Appendix A: Summary of and Responses to Agency Submissions

Agency	Comment	Response
<p>Department of Planning and Environment</p>	<p>Traffic and Access</p> <ul style="list-style-type: none"> - Spacing of 250m between signalised intersections is inconsistent with the preferred spacing/design standard of 400 m to 500 m (consistent with other parts of the SLR). - The EIS modelling does not take into account the most recent SLR concept design (refer to Figure 1). The SLR/Wallgrove Road intersection will be based on the current SLR design and accompanying GHD traffic modelling. - The EIS SIDRA modelling indicates that queues on the southern approach to the SLR/Wallgrove Road intersection would be in excess of 400 m in the 2031 PM peak. Queues of this length would extend beyond the Wallgrove Road/Gazcorp intersection. - The EIS SIDRA modelling indicates that queues on the northern approach to the Wallgrove Road/Gazcorp intersection would be 200 m in the 2031 AM peak. Queues of this length would extend close to the SLRN/Wallgrove Road intersection. - The EIS traffic report indicates that a 100 m right hand turn (RHT) storage bay is required on the northern approach of the Wallgrove Road/G

Annexure B: Wallgrove Road Intersection Concept Layout SK201

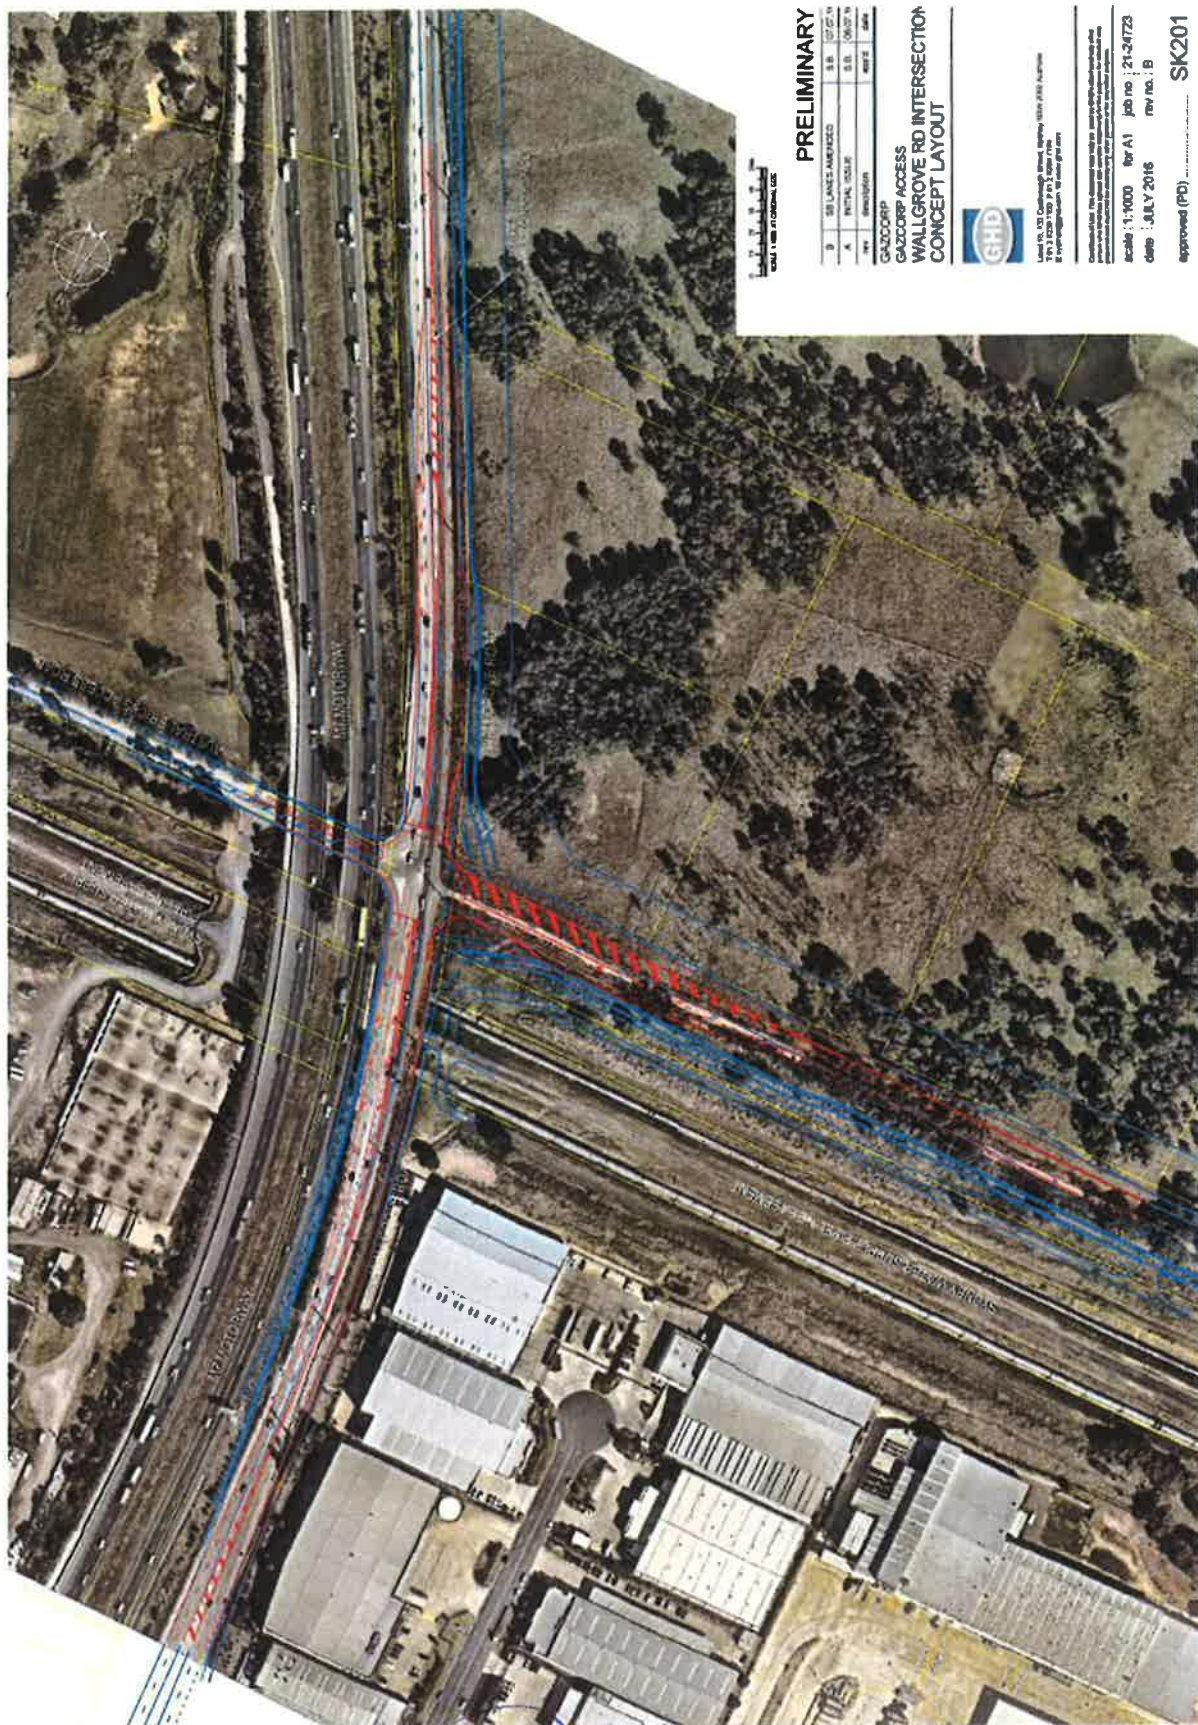
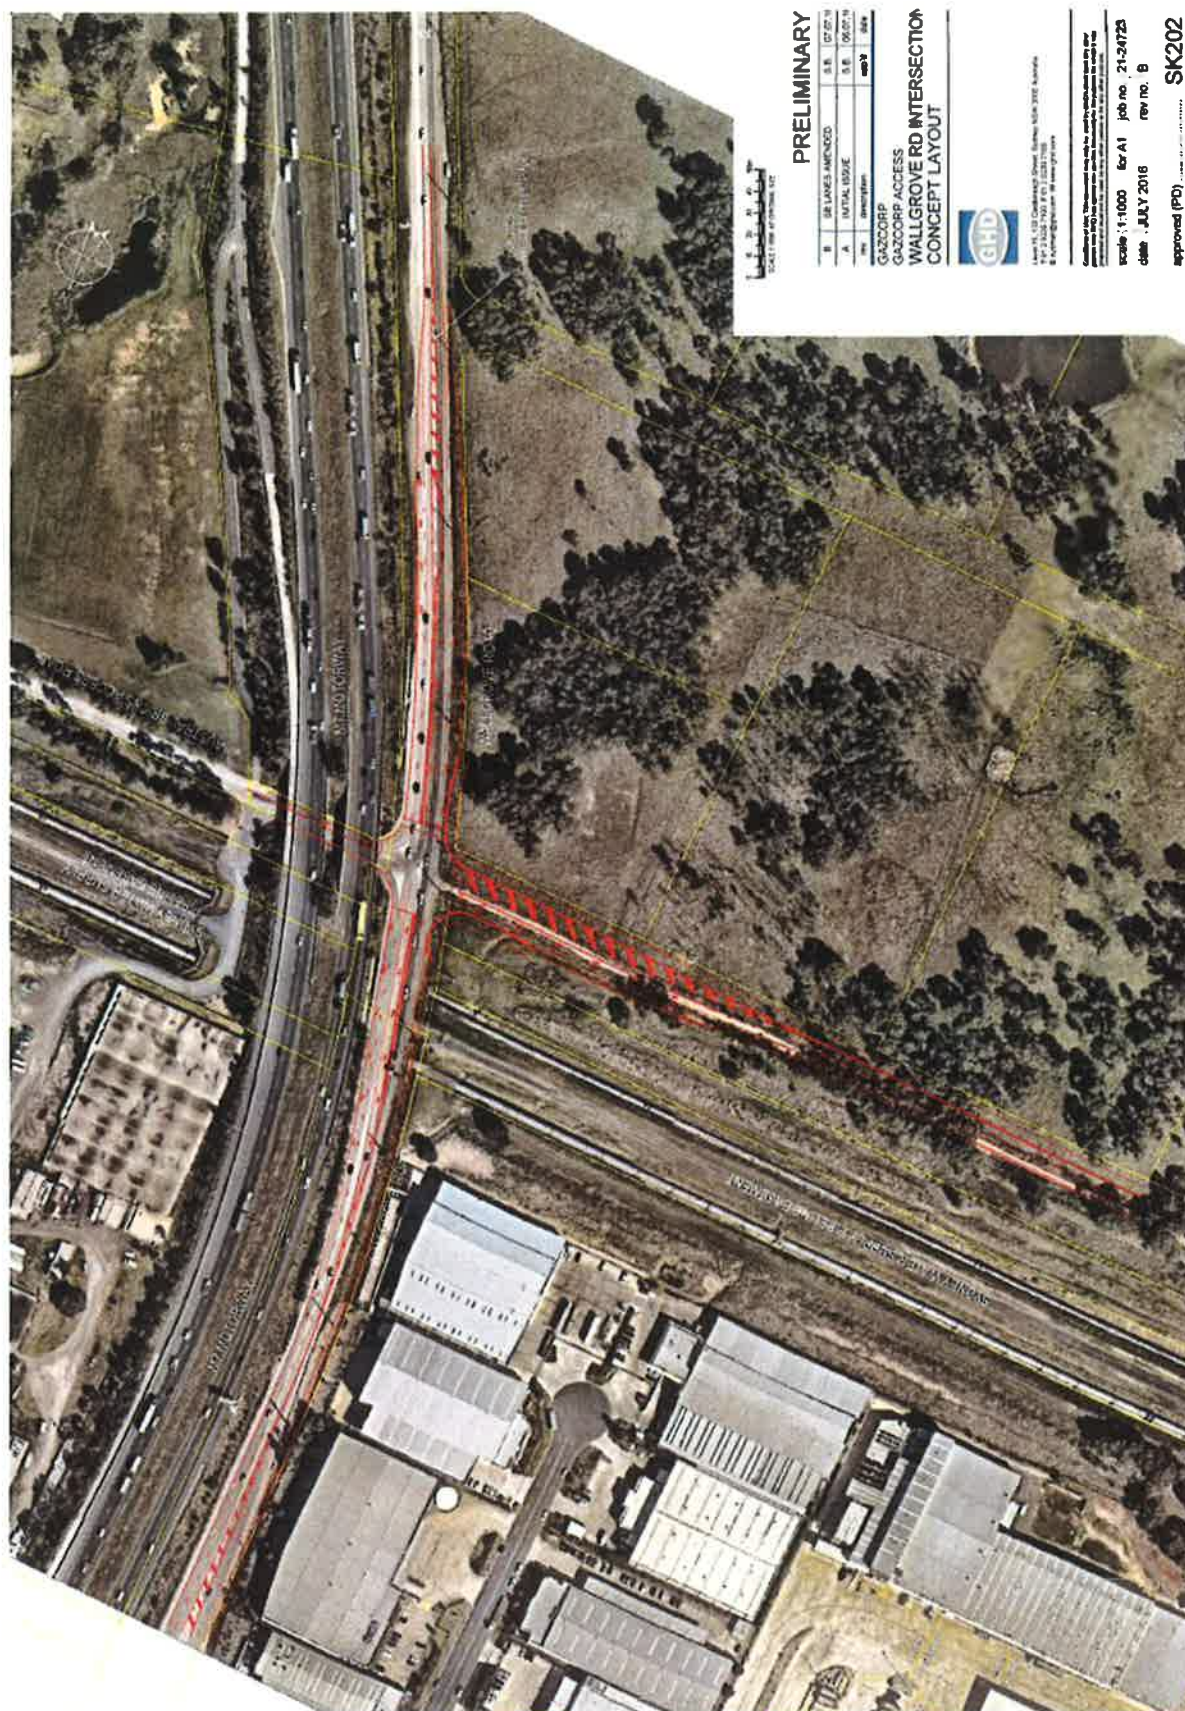
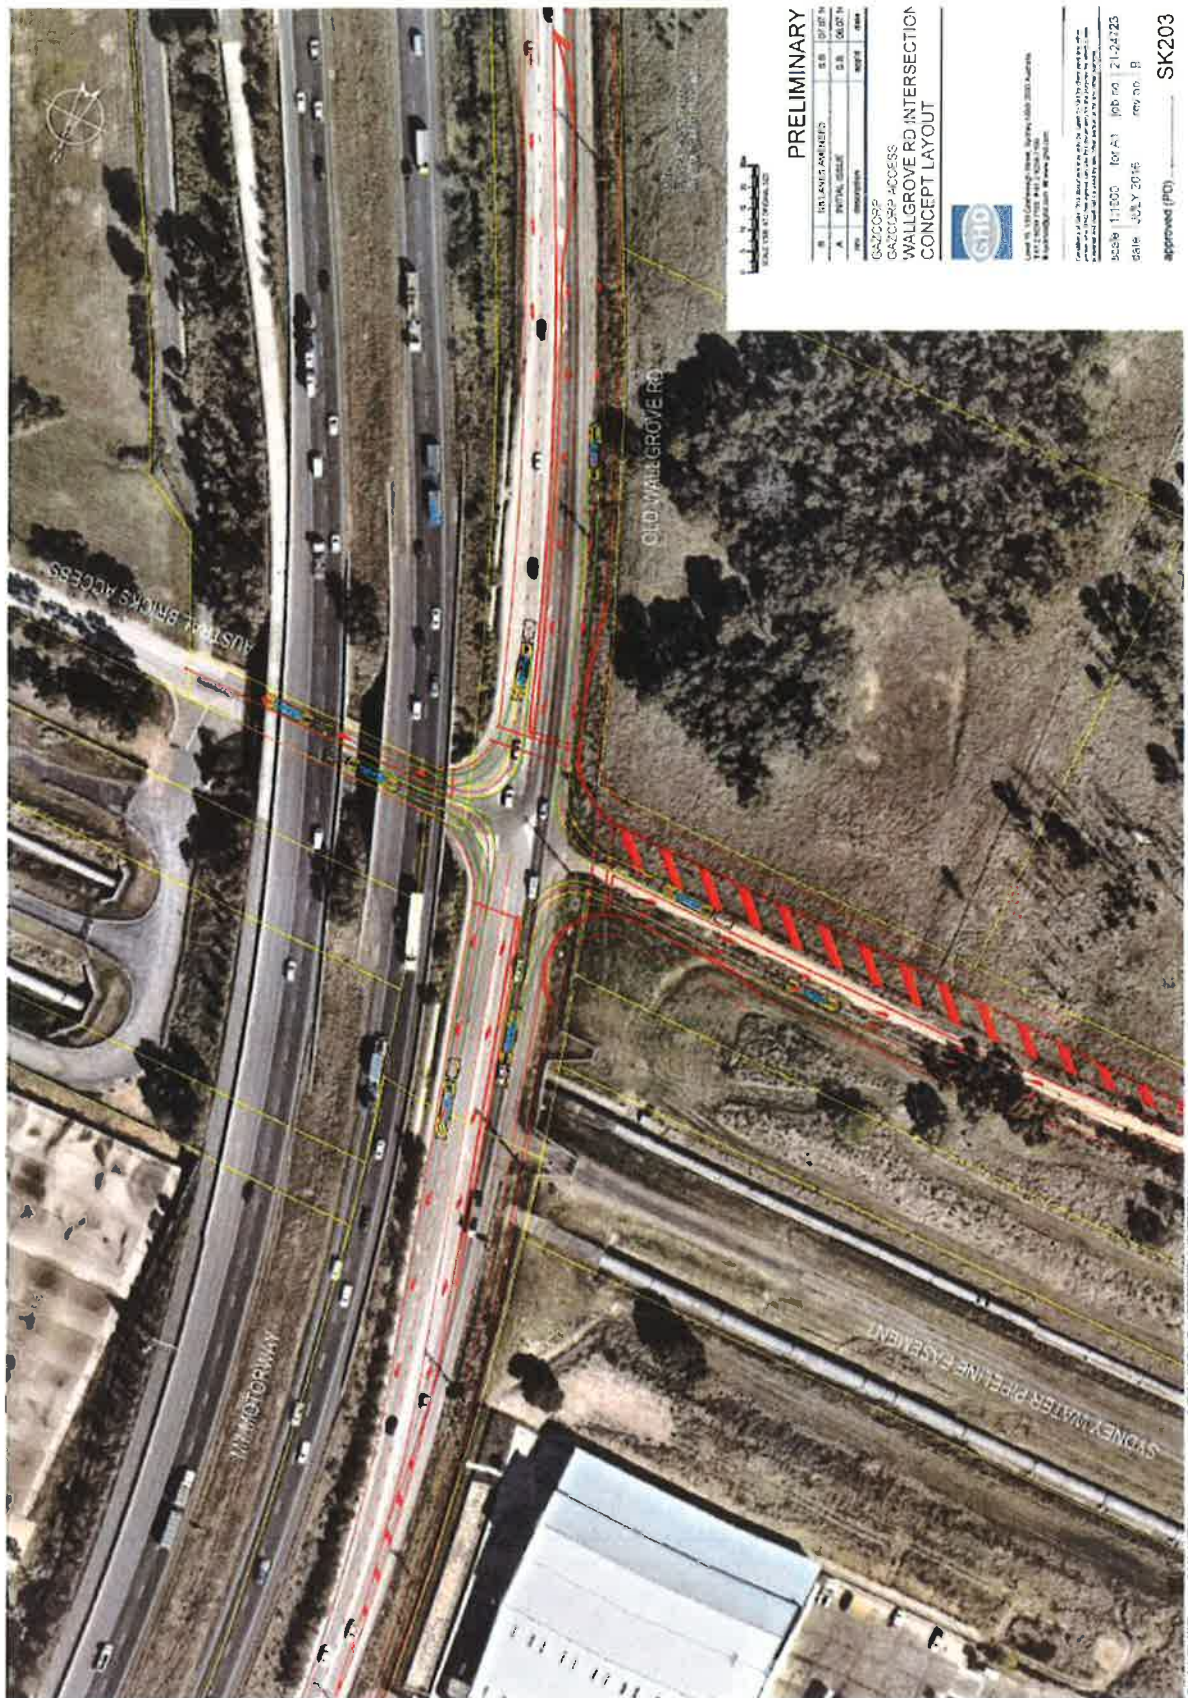
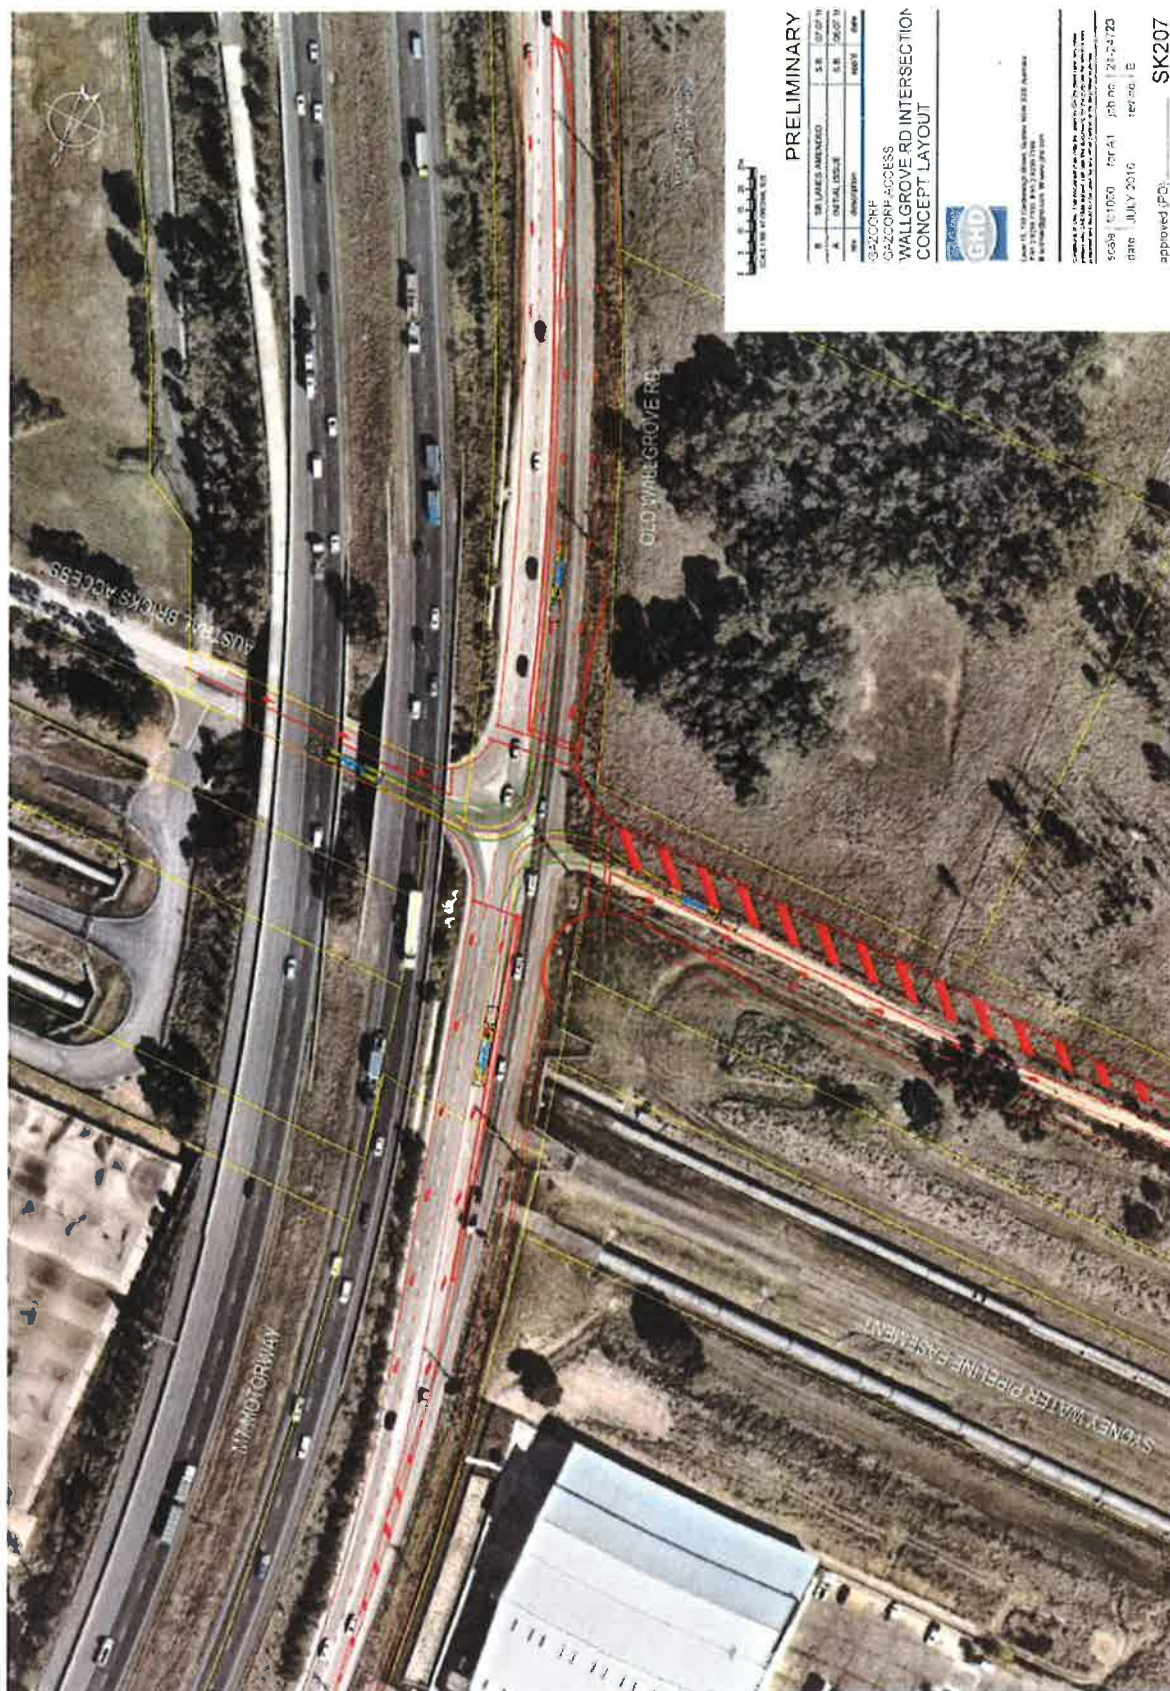
Agency	Comment	Response
	<p>intersection extents need to be considered and accommodated by adjustment to property boundaries.</p> <ul style="list-style-type: none"> - The Department requires a review of proposed Wallgrove Road and intersection designs. 	
	<p>Residential Amenity – Noise and Visual Impacts</p> <ul style="list-style-type: none"> - Provide greater consideration to the interface of the proposal with the residential properties to the south of the site. Some of the residences are within 200 m of the site boundary. - The 3 m high colour bond acoustic fence proposed as part of Stage 1 is not considered visually appropriate for a residential interface and is required to be replaced with a boundary/fence treatment which is aesthetically acceptable when viewed from the residential properties. In this regard, consideration should be given to a boundary treatment which combines earth mounding, fencing and landscaping. - Amend the EIS to include a specific section addressing residential amenity. This section should identify and map the location of nearby residences using current aerial photography. Provide specific details of measures to preserve the visual and acoustic amenity of potentially affected residences. - Boundary design treatments, including fencing and landscaping should form a component of the site Development Control Plan required under clause 18 of the State Environment Planning Policy (Western Sydney Employment Area) 2009 (WSEA SEPP). 	<ul style="list-style-type: none"> - The two closest residences to the south of the site are located within 200m of the site boundary, the closest being some 150m from the boundary. Further consideration of the south-west boundary of the site has been provided, including providing landscaping in front of the acoustic wall. It is also highlighted that the Stage 1 warehouse building is set back approximately 40m from the site boundary, behind an existing 330kV electricity transmission line and easement, and will be partially screened by existing riparian corridor vegetation of Reedy Creek. - A more detailed landscape plan has been prepared illustrating the view perspective from the south. It is highlighted that the Stage 1 warehouse building is predominantly located west of the existing transmission pylon, and is therefore partially screened from residents by the existing riparian corridor of Reedy Creek. As this land is Zoned E2 and is a protected riparian corridor it is expected that it will remain relatively heavily vegetated in the future and therefore will continue to provide partial screening. The view towards the site from the south is also impacted by an existing 330kV electricity transmission line (including a pylon). - A residential amenity section has been included into the Response to Submissions Report. - The site currently fenced by a chainmesh fence.
